From: Michael Eastham
Sent: 22 May 2020 12:35
To: Planning Scanning
Subject: FW: BN/37/20/DOC - Land Rear of Lillies, Yapton Road, Barnham

Please scan and upload the email below from the applicant confirming that we have an extension of time (EoT) to determine discharge of condition application **BN/37/20/DOC** - Land Rear of Lillies, Yapton Road, Barnham to **Friday 5th June 2020**.

From: Alison Meeus <[REDACTED]>
Sent: 15 April 2020 17:26
To: Michael Eastham <[REDACTED]>
Subject: BN-37-20

SCALE	1:500 @ A2	DATE	FEB 2020
DRAWN	CLS	CHK	JGF
DRAWING NO.	17748-BARN-5-512	REV	B
TITLE	YAPTON ROAD BARNHAM		
DETAILS	Footpath Link & Typical Footway Constructon Detail

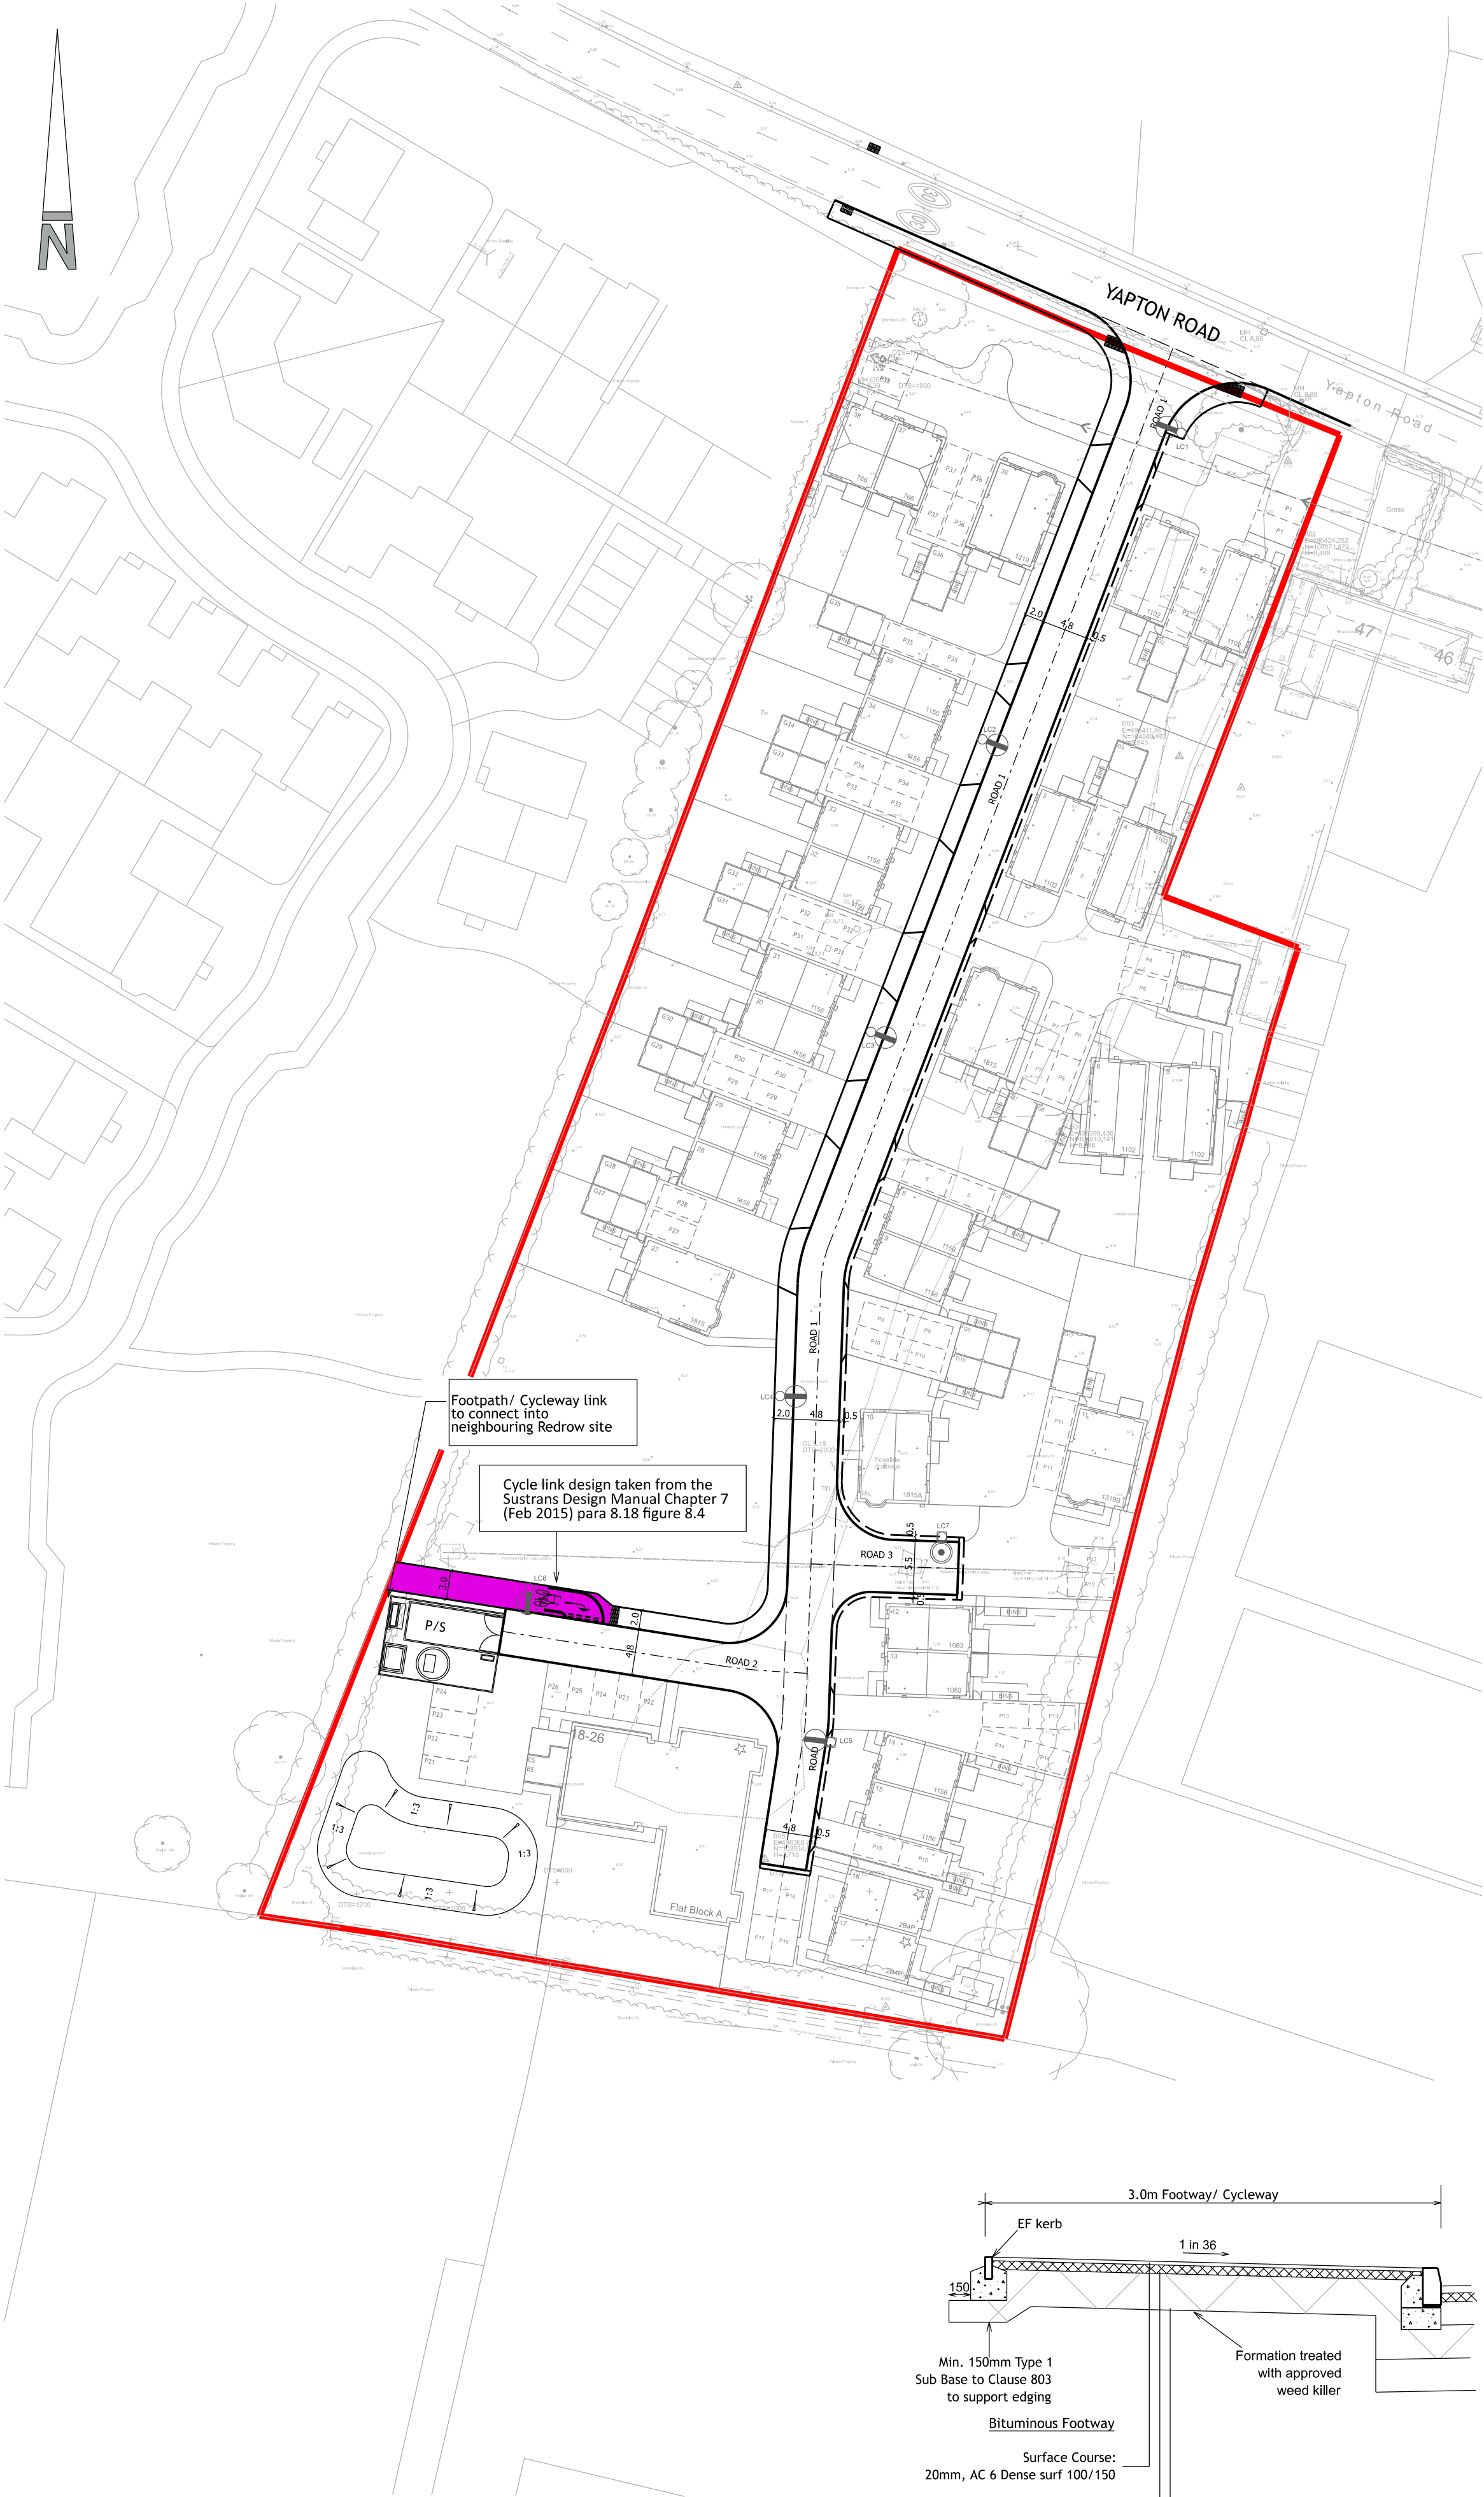
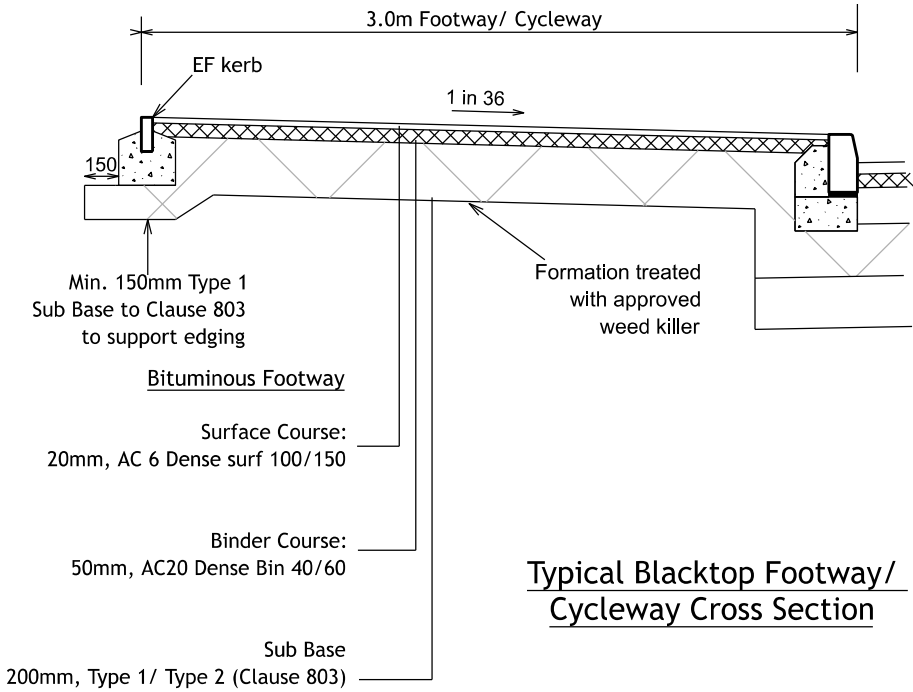
Please can you ask the applicant to confirm if they will be widening the footway on yapton road to meet the existing 3m footway, already in situ as part of the (redrow) angel nursery development. This only needs to be 3m wide on Yapton Road, the internal road can stay at 2m, and the proposed cycle path connecting the two sites can stay as per the plan.

We would prefer this is road safety audited, a 1 and 2 audit will be required, before the S278, please can this be arranged.

Many thanks for getting back to me so promptly. I have spoken with our implementation team who has been in contact with the local member for the area. Apparently this is something which is supported locally however; the need for a 3m path would only be required on Yapton Road, the internal access could still remain at 2m.

Unfortunately it seems no RSA process was raised at any of the previous applications, so as it stands the proposal to continue the 3m footway along the Yapton Road only would be achievable at this stage without any other changes being required. This would benefit the whole community, have amenity benefits, and also provide consistency with the adjacent development. Please can you ask the applicant to re-consider?

Having checked with the team, I understand the comment for a 3m wide pedestrian/cycle link has been raised for the first time and it wasn't part of the consultations at both Outline and Reserved Matters stages which showed a 2m wide path. The condition at RM notes a pedestrian / cycle link to be provided between the site and adjacent site, which a 2m wide link does.

Also, looking at the consented site layout we appear to be quite constrained along the access road, especially at the north between plots 2 and 36. Trying to accommodate a 3m link at this stage will fundamentally alter the consented site layout while making the roads the dominant feature on what is a small development. Looking at the google maps there doesn't appear to be a 3m wide footpath on the main Yapton Road itself, which has a narrow footpath on the opposite side of the road.

Whilst plans submitted show a cycle path linking the internal site roads of the adjacent housing development (known as angel nursery site) it has been brought to my attention that there should also be a cycle path (3m wide) on the left hand side of the access, linking into the development.

From a planning perspective we would not wish to see an opportunity for encouragement of sustainable travel like this to be missed. Also it is not logical for the path to change from a 3m wide shared use cycle/footpath to a footpath on such a short section of footway. Hopefully you will see the logic, and as such would appreciate it, if you can ask the applicants to revise the drawing to include the extension of a 3m path along yapton road, from the angel nursery side, into the proposed access.

I have also noticed this will need road safety auditing, and will require both a stage 1 and 2 audit, which can be undertaken together to ensure all highway safety issues have been considered.
Therefore until I receive further information I am unable to discharge the condition.

Without getting drawn into a discussion on the S.278 design, which Highways will be leading anyway, for the purpose of discharge of this planning condition, if you are in agreement of a consistent 2m wide path internal to the site, from Yapton Road to the point of connection with the adjacent site, we can get the drawing revised to reflect this as it currently shows a 3m section towards the end.
